<b>Application Ref:</b>	2026/0017				Ribble Valley Borough Council <a href="http://www.ribblevalley.gov.uk">www.ribblevalley.gov.uk</a>
<b>Date Inspected:</b>	24/02/2026	<b>Site Notice:</b>	N/A		
<b>Officer:</b>	EP				
<b>DELEGATED ITEM FILE REPORT:</b>					<b>REFUSAL</b>

<b>Development Description:</b>	Retrospective consent for proposed new double garage on the site of previously approved garage.
<b>Site Address/Location:</b>	2 George Street, Whalley BB7 9HT.

PROPOSED PLAN AND ELEVATIONS  
NEW TIMBER FRAMED GARAGE  
NO 2 GEORGE ST, WHARFUM  
MR + MRS. M. GIBSON  
SCALE 1:100 @ A4.

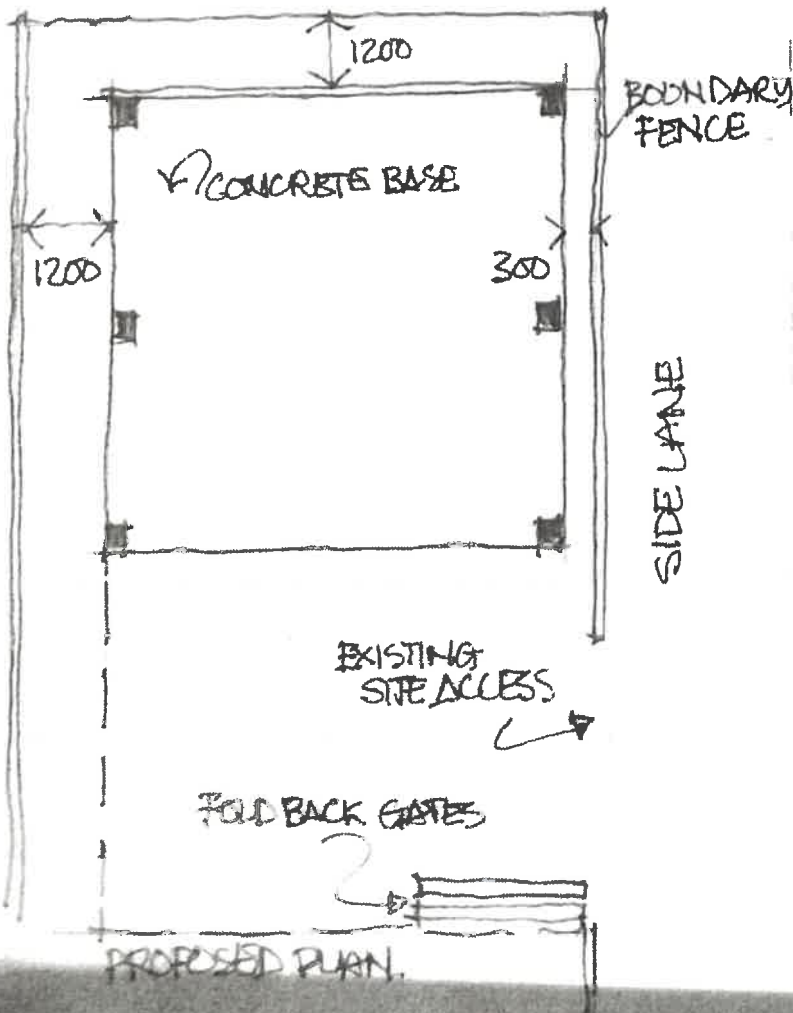
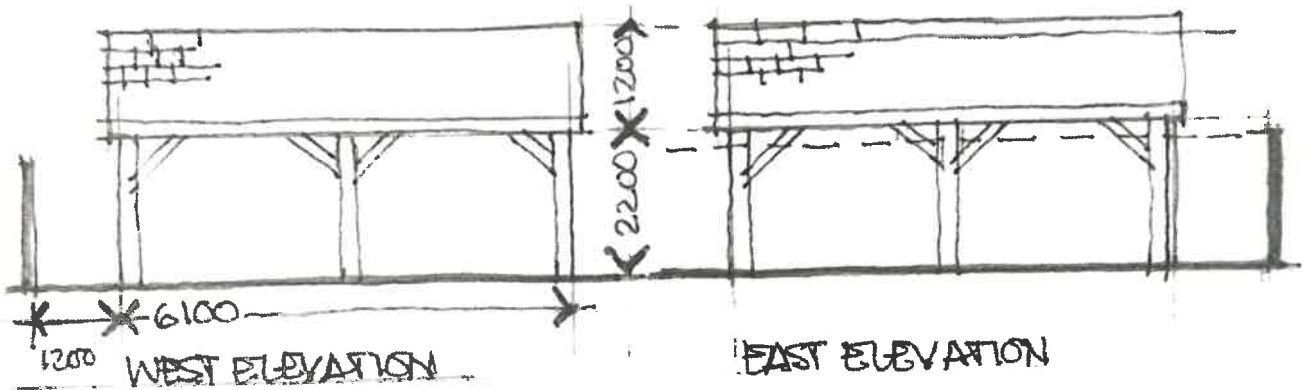
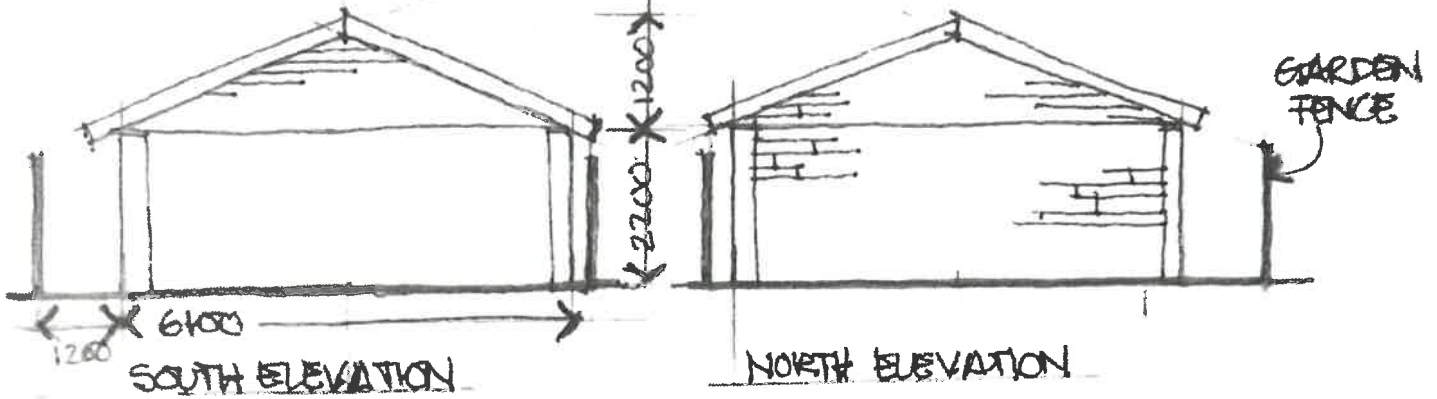
Whilst the separation distance is maintained, the change in orientation now means the amount of solid built form along the shared boundary appears greater, by virtue of the entire gable facing the neighbouring dwelling. This area of rear garden is narrow and therefore susceptible to any visual change along its boundaries. Additionally with a narrow garden this means that the proposed additional built form is also in close proximity to windows in the south elevation of this neighbouring property. The proposed change in built form adjacent to the boundary here results in an adverse level of overbearing impact and loss of light.

Whilst it is appreciated that a timber structure on the neighbouring property does mitigate the impact somewhat, on balance the proposed building is deemed unacceptable on neighbouring amenity grounds. The as-built garage results in loss of light to the residential curtilage of neighbouring receptors and an increased sense of overbearing contrary to Policy DMG1 of the Ribble Valley Core Strategy and Paragraph 135 of the NPPF.

The garage structure that has been built, is sited almost immediately adjacent to the access road. The submitted plans suggest that there is a 400mm gap between the garage and the boundary fence, although when observed on site the gap appeared smaller, particularly when taking into regard the roof overhang. Whilst the proposal is sited to the rear of the dwelling, the road that runs adjacent provides access to a number of dwellings and as such the proposal is afforded public views. In addition, due to the change in orientation, the as-built garage structure does not integrate into the boundary fence, and the structure is afforded significant views from the new vehicular access point. As such, the as-built garage structure is far more visually prominent than the approved garage.

In respect of materials, the approved garage building was to be constructed in red brick, which is consistent with the vast majority of properties / built form in the immediate vicinity. There are also similar garage structures/storage buildings to the approved development adjacent to the application site. The as-built structure is of timber construction with a tiled roof profile. The choice of timber appears anomalous within the street scene by virtue of a lack of similar materials or structures in the vicinity. Furthermore, the timber structure appears stark in contrast with the red coloured roof tiles and other red brick structures in the

street scene. The choice of materials, being anomalous in this location, further exacerbates the visual prominence of the structure, particularly given there is no set back from the access road.

A timber structure of this scale and design, with exacerbated visual prominence being adjacent to the access road, appears anomalous and out of character with the street scene and resulting in harm to the character of the adjacent Conservation Area, contrary to Policies DMG1 and DME4 of the Ribble Valley Core Strategy and paragraphs 212 and 215 of the NPPF.

<b>01:</b>	The proposed development results in the introduction of an anomalous and visually prominent addition to the street scene which is also harmful to the character of the adjacent Conservation Area, by virtue of its scale, siting, roof design and materials, contrary to Policies DMG1 and DME4 of the Ribble Valley Core Strategy and Paragraphs 212 and 215 of the National Planning Policy Framework.
------------	---

<b>02:</b>	The proposed garage results in unacceptable loss of light, sense of enclosure and overbearing impact for the occupiers of neighbouring property 'The Old Exchange' by virtue of its scale, siting and roof design, contrary to Policy DMG1 of the Ribble Valley Core Strategy and Paragraph 135 of the National Planning Policy Framework.
------------	--

SHEET:
PROPOSED GARAGE PLAN
& ELEVATIONS

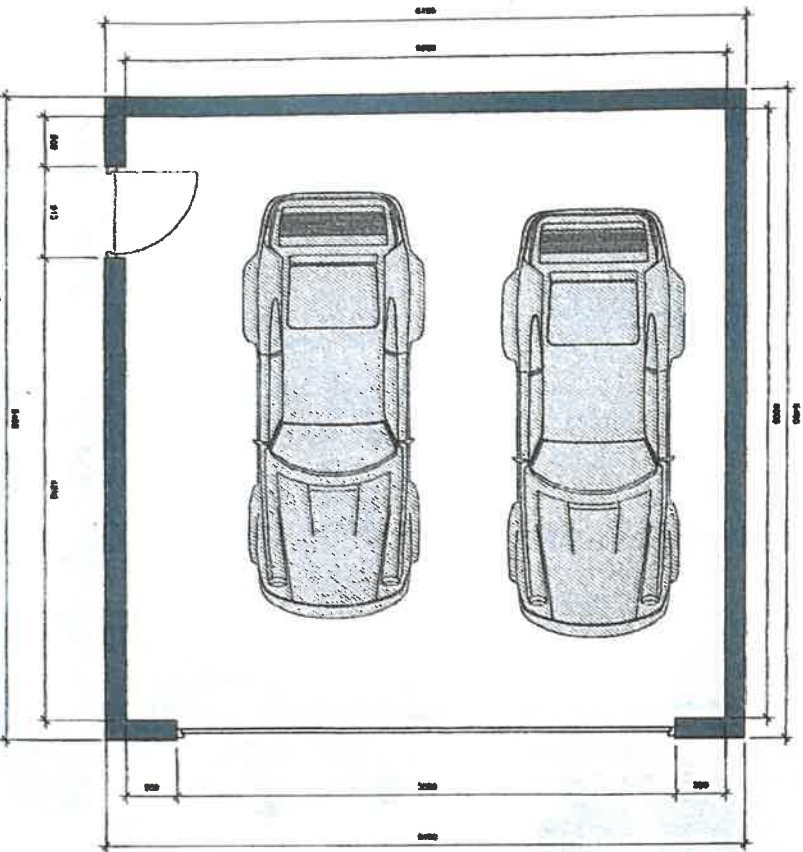
The application structure is located in close proximity to the shared boundary with neighbouring dwelling, The Old Exchange. The approved garage structure had an orientation that resulted in the pitched roof sloping away from the shared boundary with The Old Exchange, together with a 1m separation distance, and that scheme was considered to have an acceptable impact in terms of loss of light and overbearing (as stated above it is not considered this scheme could be implemented in any event).

Under application 3/2024/0361 a replacement garage building was approved. This building was comparable in design to a previous building on the site which has been demolished and of the same orientation but sited further north. The building integrated into the existing boundary fence panels with a small set back from the access road and as such was considered to have an acceptable visual impact within the street scene. When viewed from the access road, the approved garage was set back from the rear curtilage by 1.14m and from the access road by 1.06m. As stated above it is not considered this scheme could be implemented in any event.

PRE CONSTRUCTION + AS BUILT
SITE PLAN.

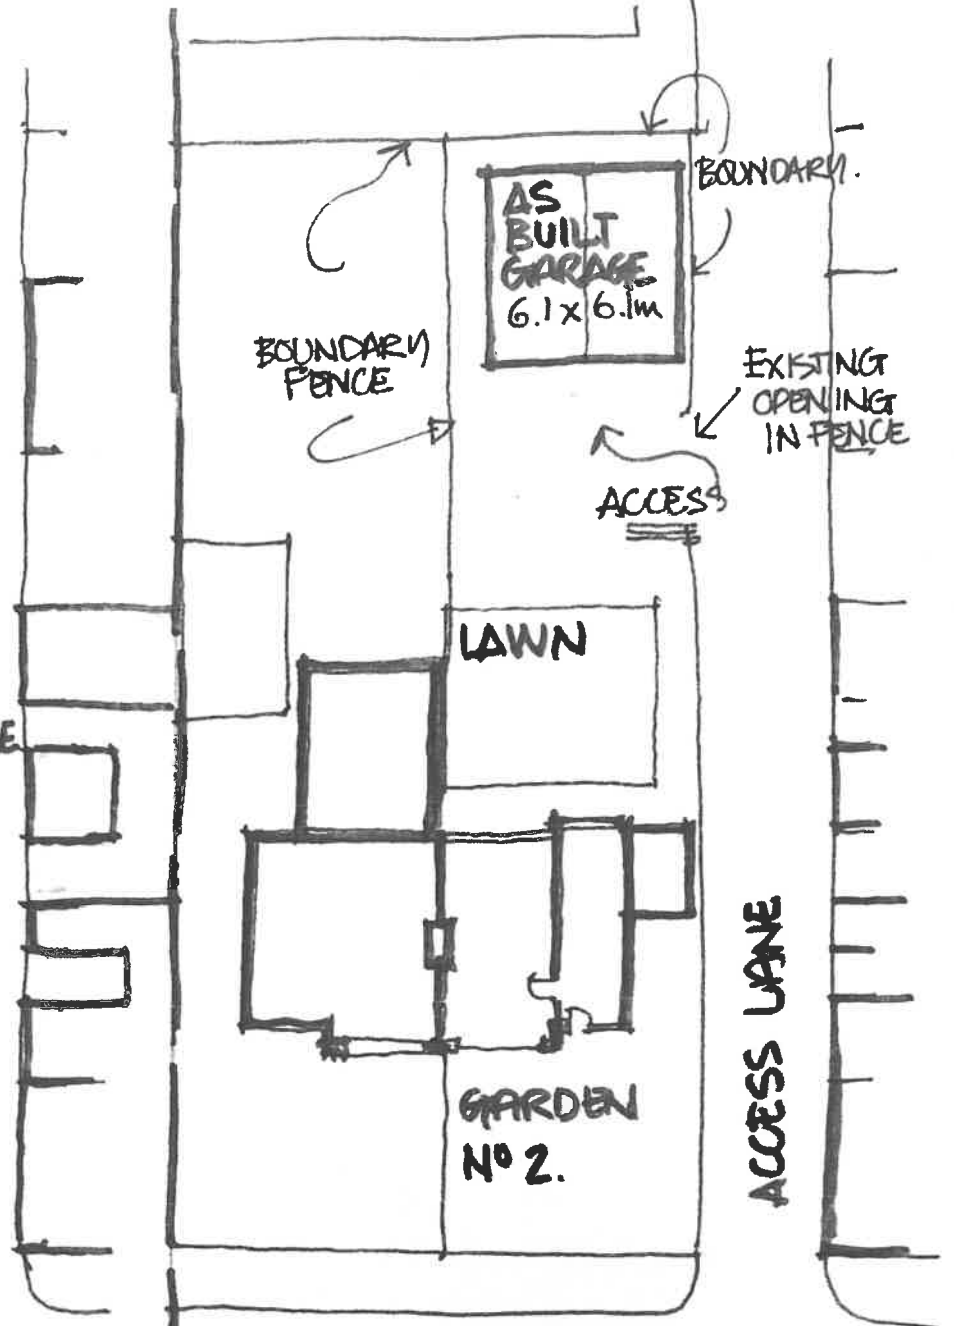
Highways comments do not directly address the altered arrangement, particularly in relation to the new access and driveway. However, on the basis that there was a garage at the siting of the new vehicular access previously, which had the potential for vehicles to enter and exit, the new arrangement is not expected to result in adverse impacts from a highways amenity perspective.
